75 Highland Rd. 109. Dr 11-11-11-
Drawing No. 1

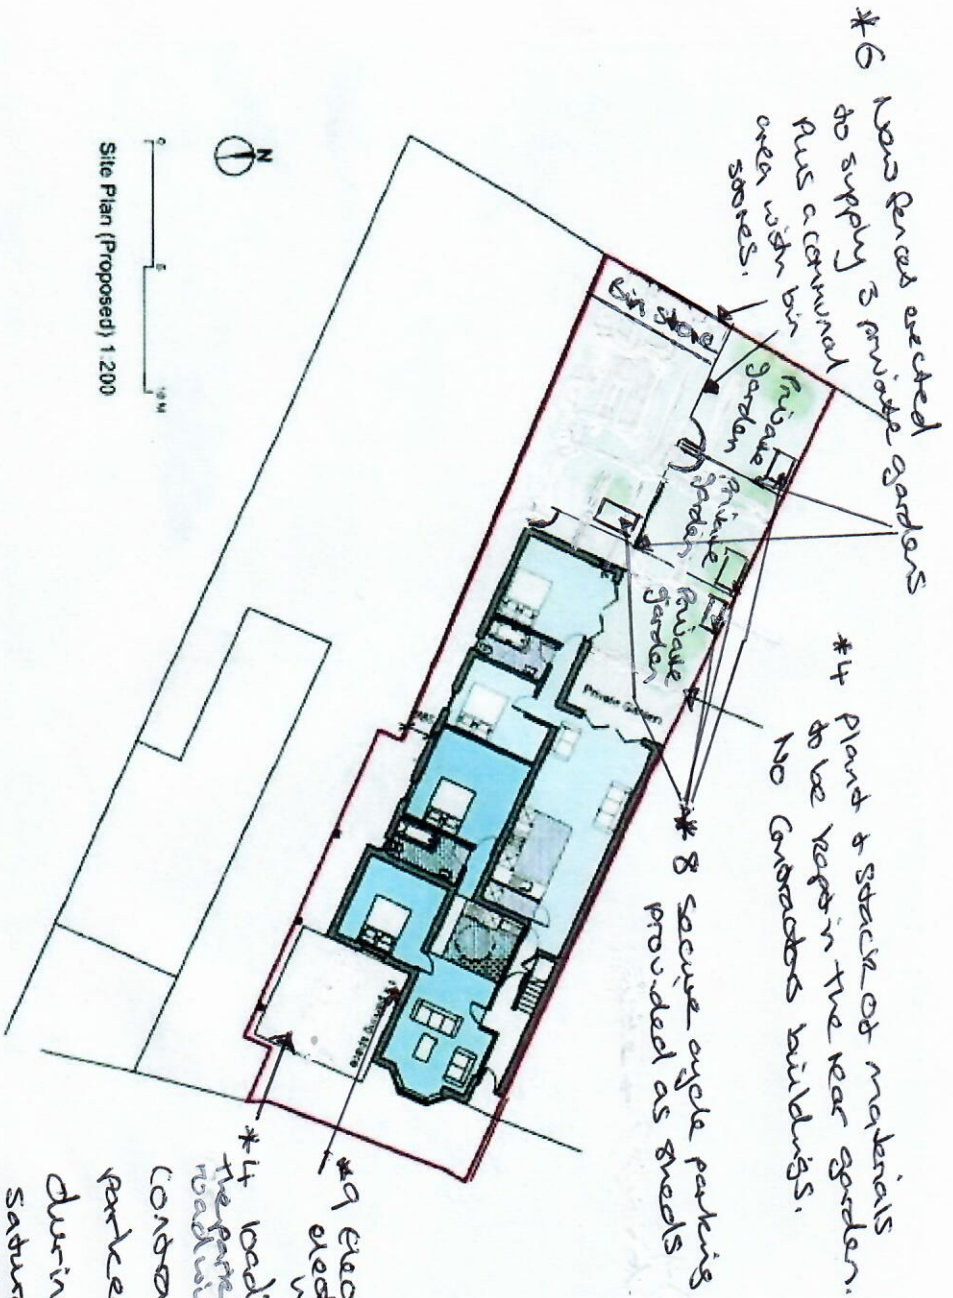
Thank you for that confirmation. I have just noticed that there is a problem with your drawing No. 1 (Site Plan) in that it is not based on the correct layout as it shows a second parking space. Please provide this drawing again as based on the approved plan (attached)
